Subject: Planning App No: 3/2012/0790 - Livery, Game Keeper's Cottage, Park Road, Gisburn

Please be advised that Gisburn Parish Council discussed the above application at their meeting last night.

SITE PLAN

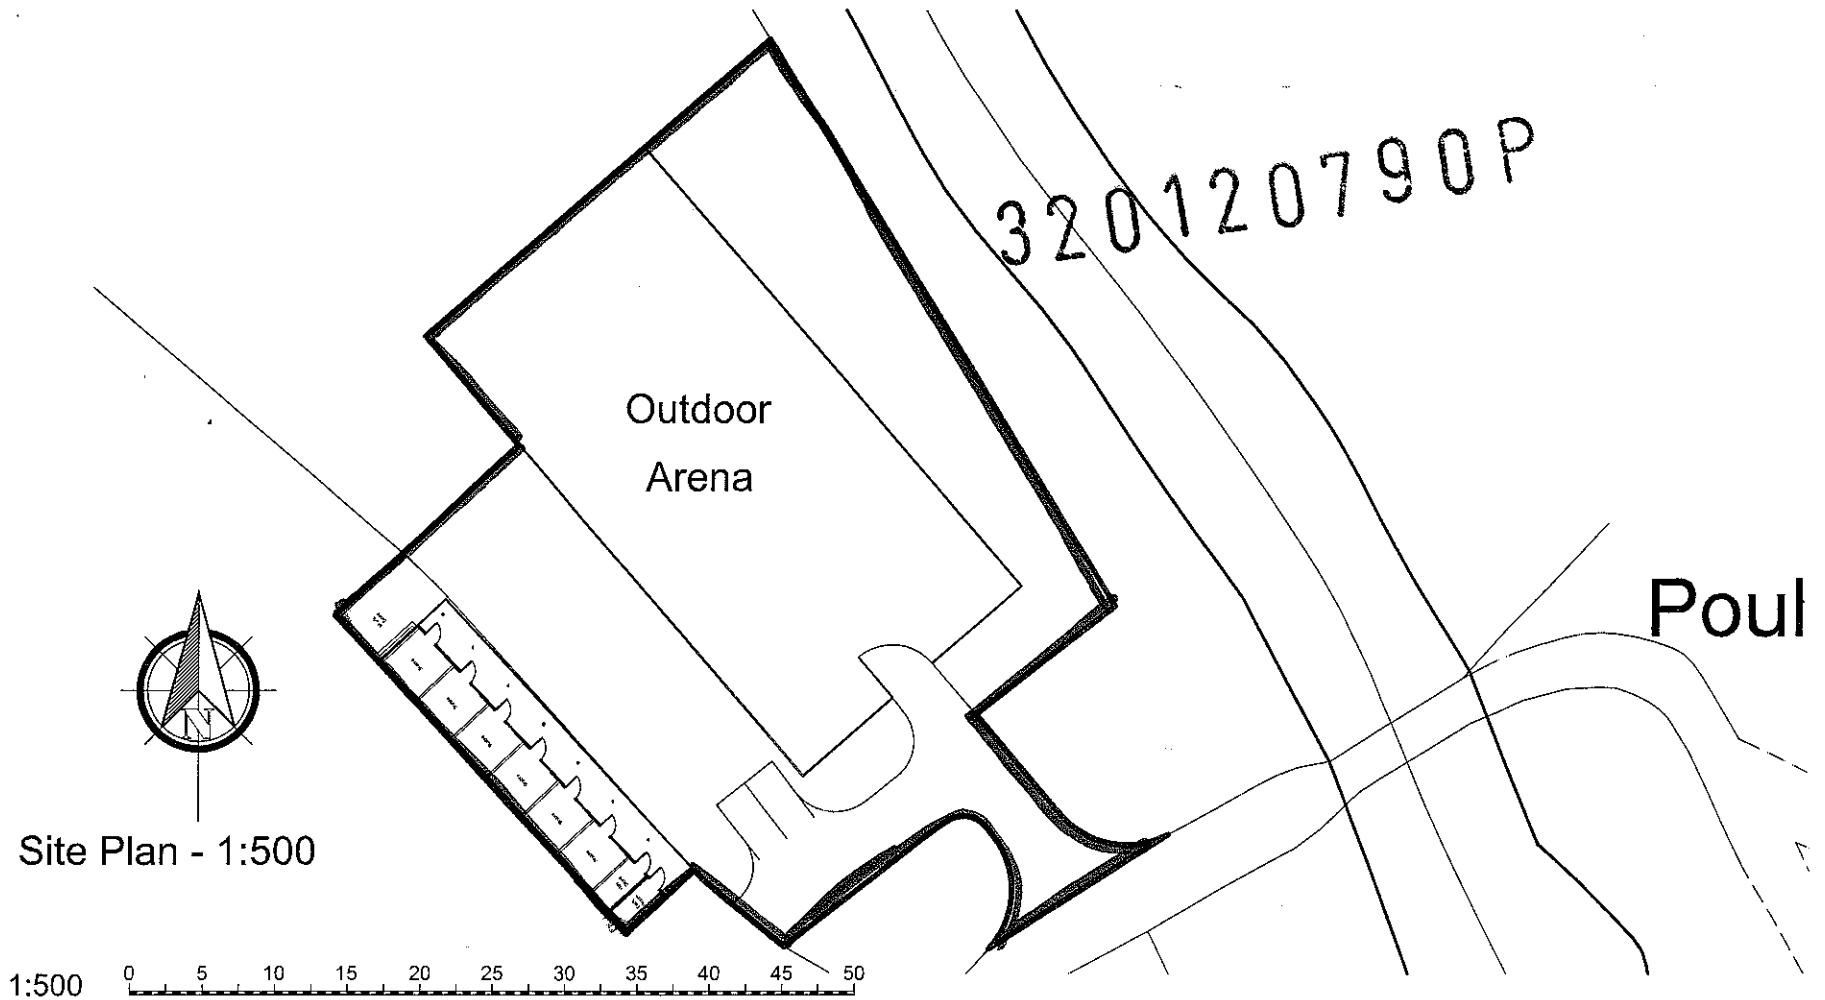
The site for the outdoor arena is apparently often waterlogged so is not the ideal location but that is the applicant's problem.

There does not seem to be any provision for parking of vehicles once at the stables/arena. If vehicles park on the road there could be further access problems.
